**Consultation Response from KC,
Lead Local Flood Authority**

2023/91431 land south of, The Lodge and north of Church Lane, Linthwaite, Huddersfield

Discharge of conditions 7 (internal roads), 8 (Church Lane crossing), 12 (electric vehicle charging), 13 (waste storage and collection), 17 (attenuation basin), 18 (flood routing), 23 (crime prevention) and 32 (landscaping) of previous permission 2021/91571 for erection of residential development for 125 dwellings

Date Responded: 5th June 2023

Client: The Casey Group Ltd	Project: BROADOAK FARM, LINTWAITE	Drawn: AL	Checked: SA	Approved: ME	Date: 23/12/20
Issue: PLANNING	Title: GENERAL ARRANGEMENT	Dwg No: UG_721_LAN_GA_DRW_01	Scale @ A1: 1:500	Revision: P13

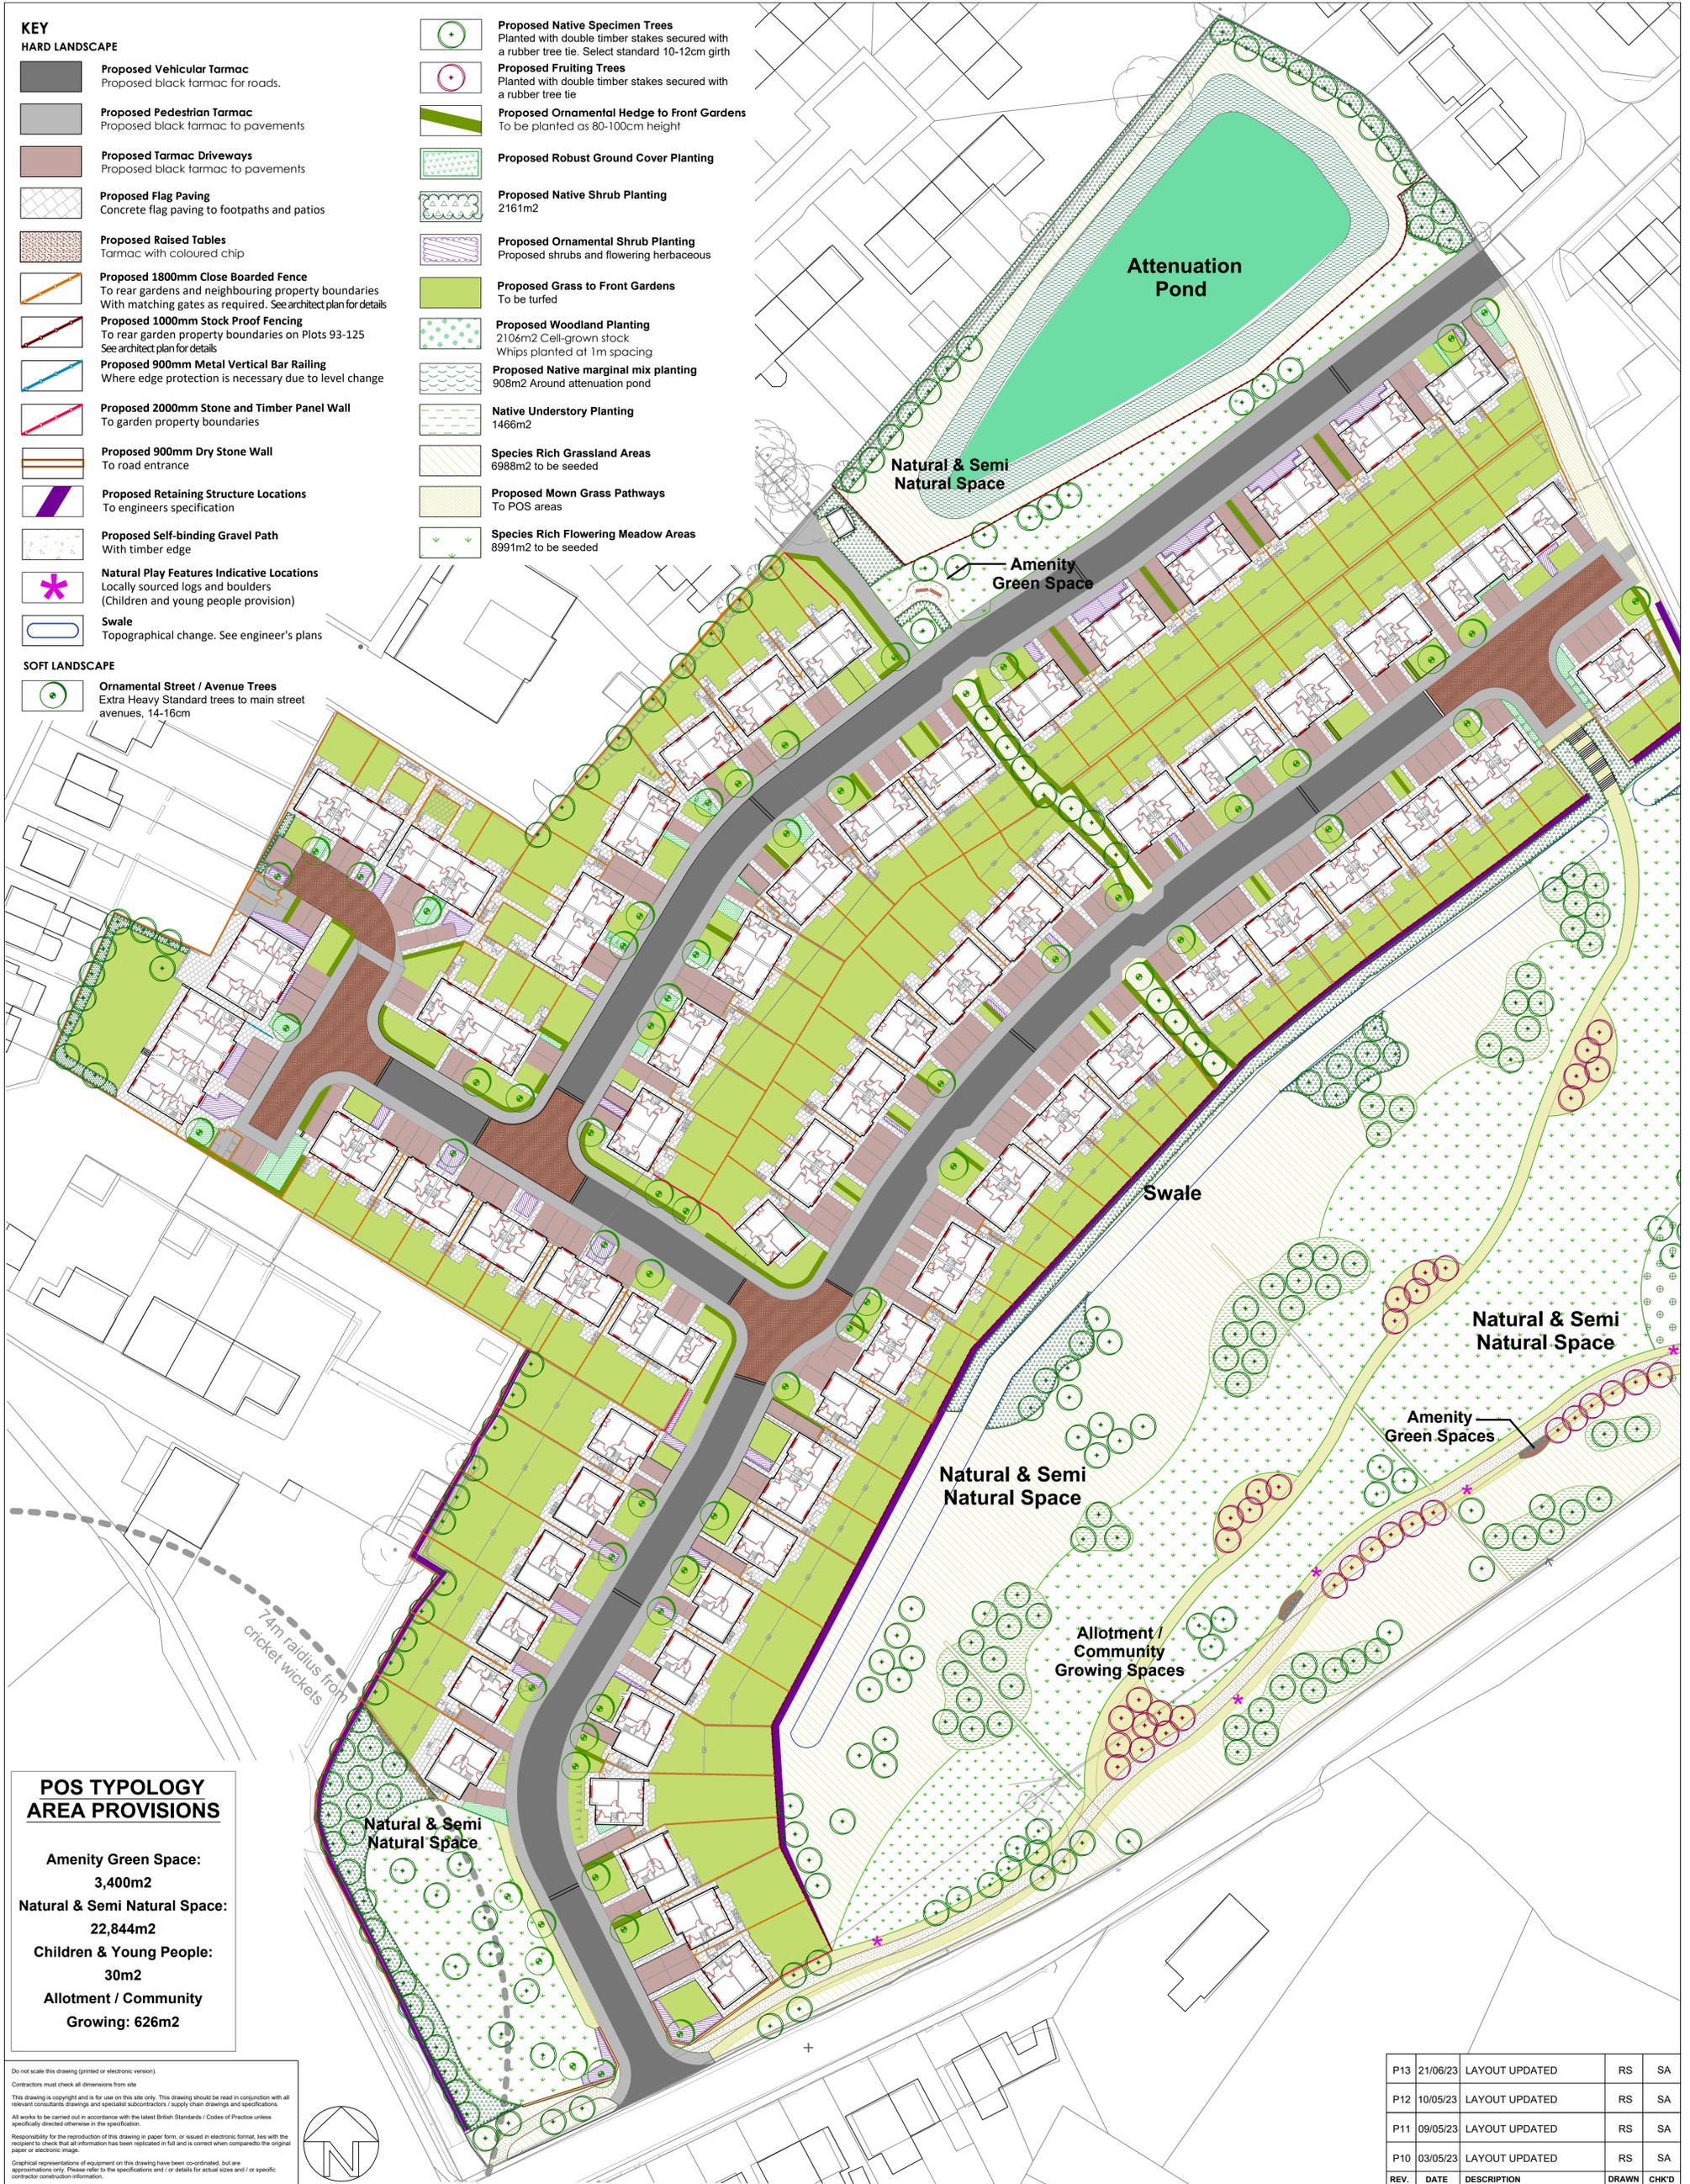
To discharge this condition and for a belt and braces approach, we would like to see the bund/swale to protect plots adjacent to the undeveloped slope in the site, incorporated on all other drawings, e.g., setting out drawings, general layout drawings and all landscape drawings. The latter appears to have tree planting in the same area and joined up thinking is required. We have experienced a failure to construct such flood mitigation measures when it is only shown on drainage specific drawings.

Adaptation of other drawings, in particular landscaped drawings, to reflect drainage mitigation engineering works is required in order to discharge this condition. Please refer to Emma Mills and Landscape conditions
